ADC PARKS & GREENSPACE ARBORICULTURE

PLANNING APPLICATION: FP/95/16/DOC

ADDRESS: Site 6 Phases 4 & 5 Land north of Felpham Felpham PO22 8FX

BRIEF DESCRIPTION: Application for approval of details reserved by condions 4 (drainage) & 8 (landscaping) imposed on planning reference FP/55/15/PL.

Drawing No.
D1530.L.381

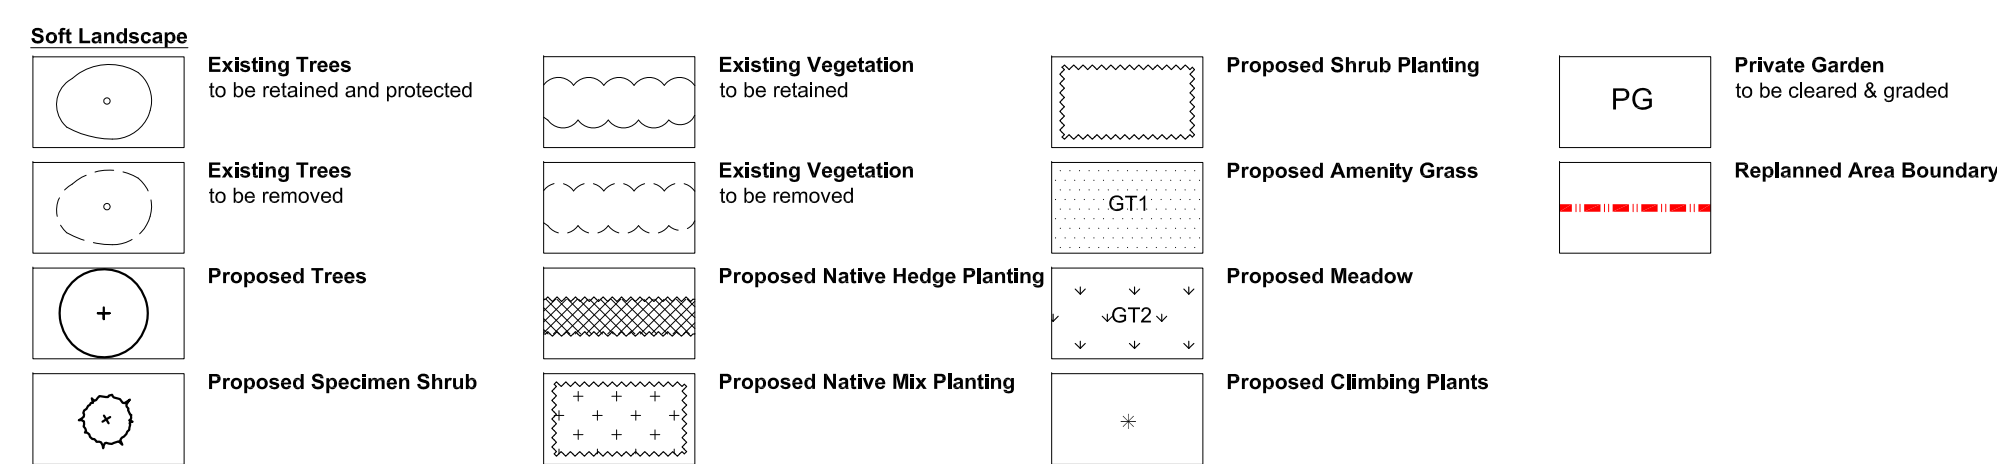
- For D1530. L.380, the proposed planting scheme east of plot 97 does not show the retained liner belt of trees (namely G16 and G17) in relation

to the proposed understory planning. Also there is no boundary treatment shown for Plots 57, 99, 98 or 91.
